DRB Application No.: 04DRB-00841	Project # 1003411
Project Name: GRANT TRACT	
Agent: Surveys Southwest, LTD	Phone No.: 505-998-0303

DEVELOPMENT REVIEW BOARD--SPEED MEMO

**CITY OF ALBUQUERQUE
PLANNING DEPARTMENT
Development Review Board
June 9, 2004
Comments**

RE: Grant Tract, Lots 14 & 15/minor plat

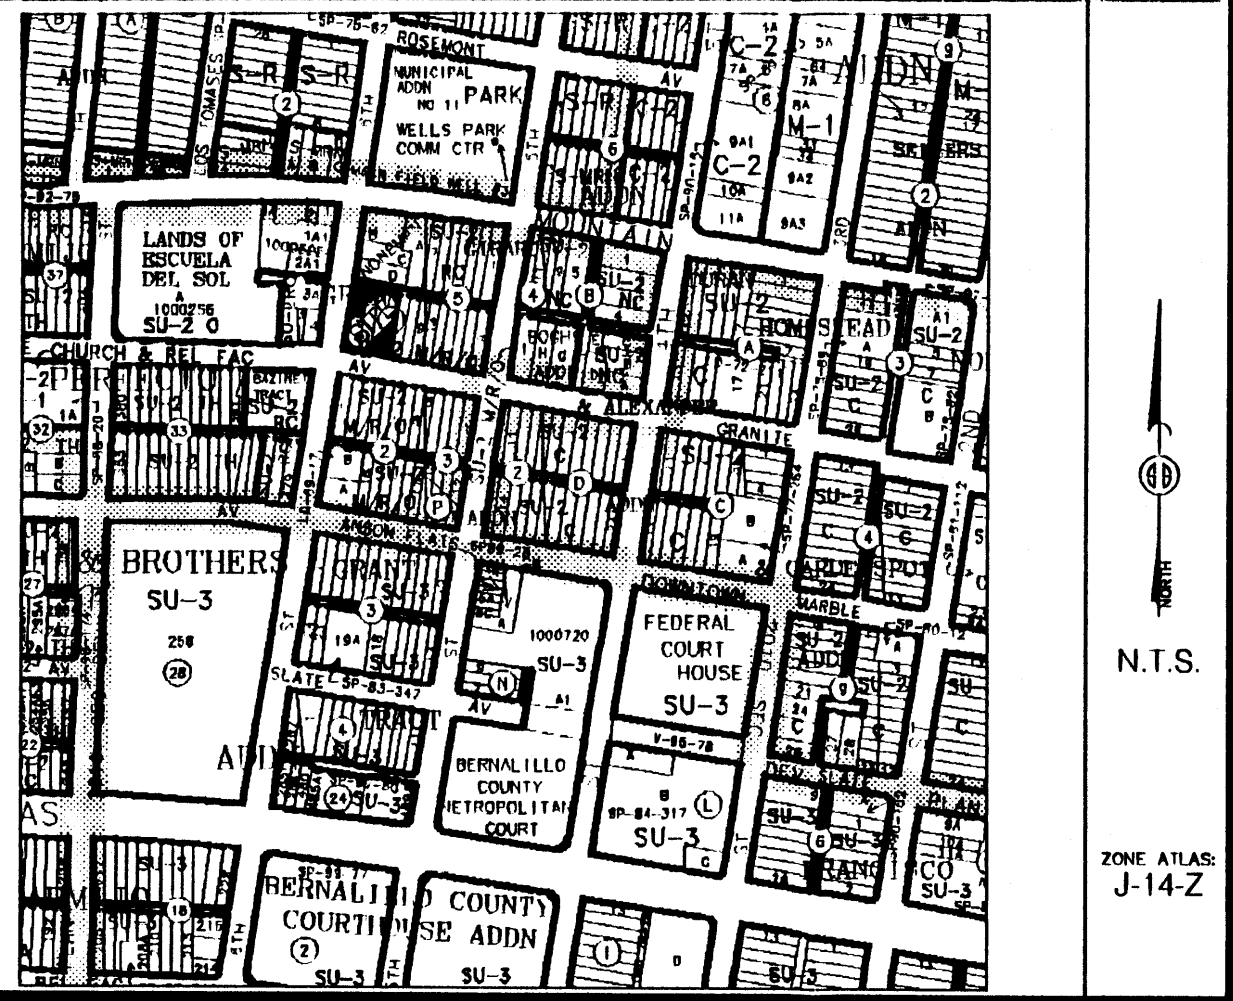
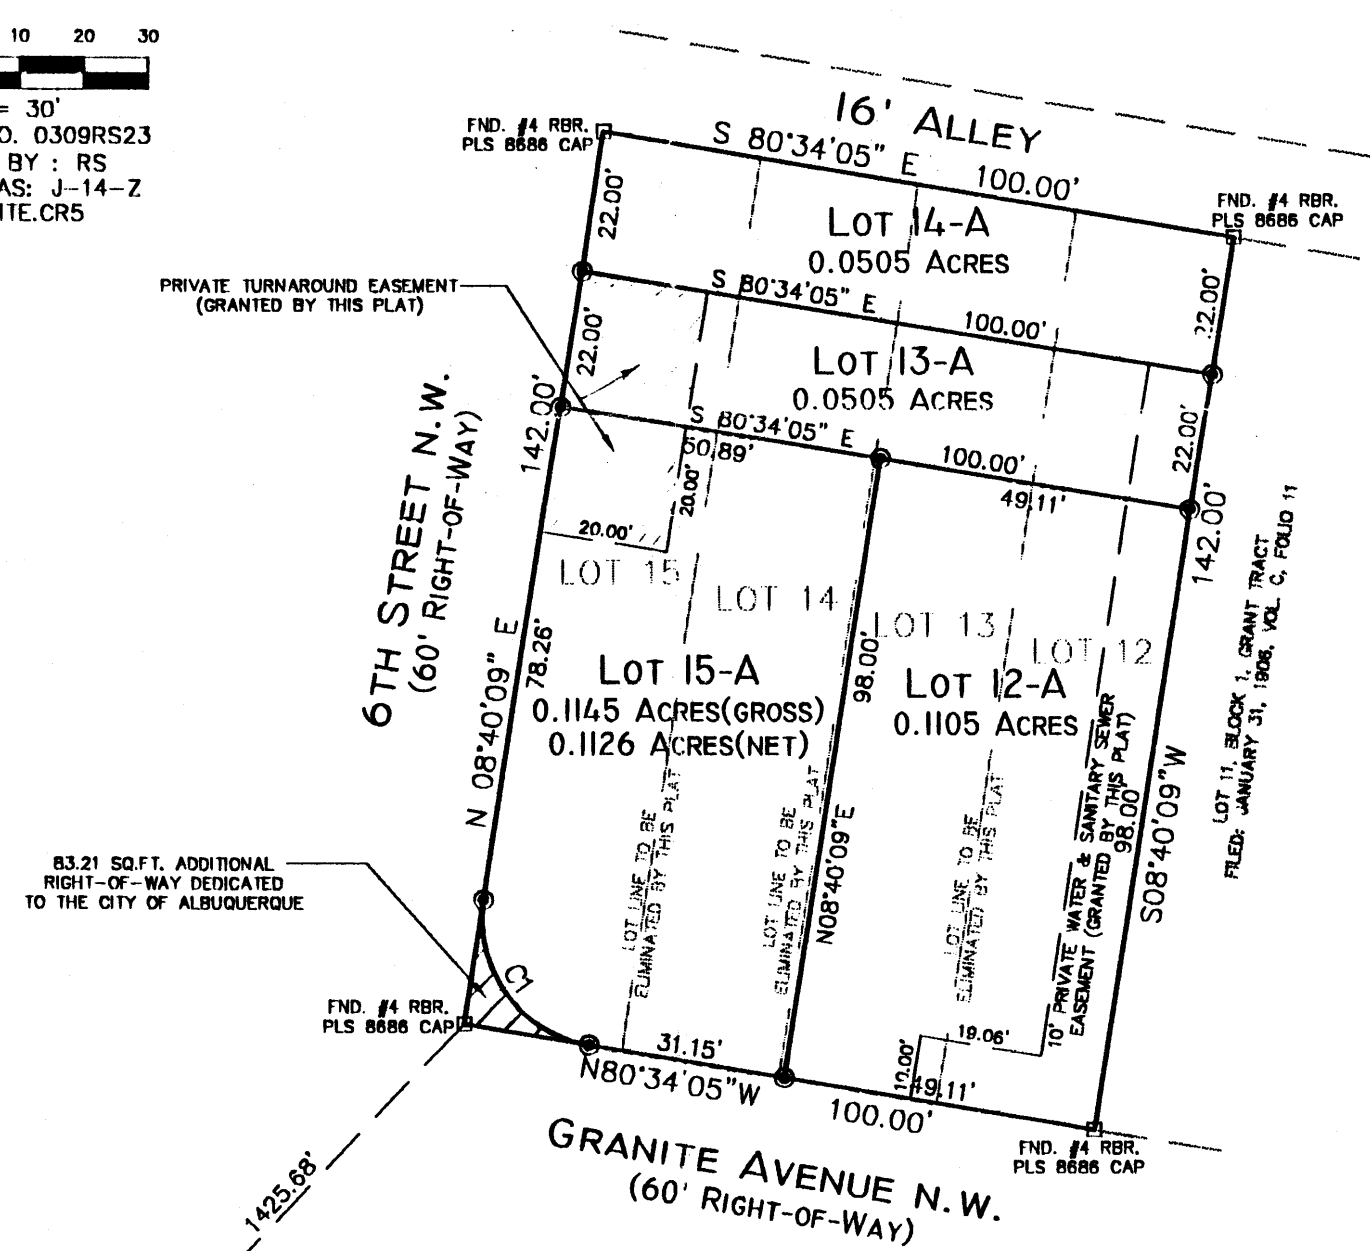
An approved grading plan is required for final plat approval. Engineer's certification required for City Engineer signoff.

The minimum lot size for property within the Downtown Neighborhoods Sector Plan boundaries is 2,000 square feet. Two of the lots barely meet this requirement.

1. Water and sewer service taps for the new lot would have to be made to the existing lines on the west side of 6th street. Existing sanitary sewer interceptor on the east side of 6th is not available for service connections.

2. Must have a fire hydrant within 450 feet of the lots.
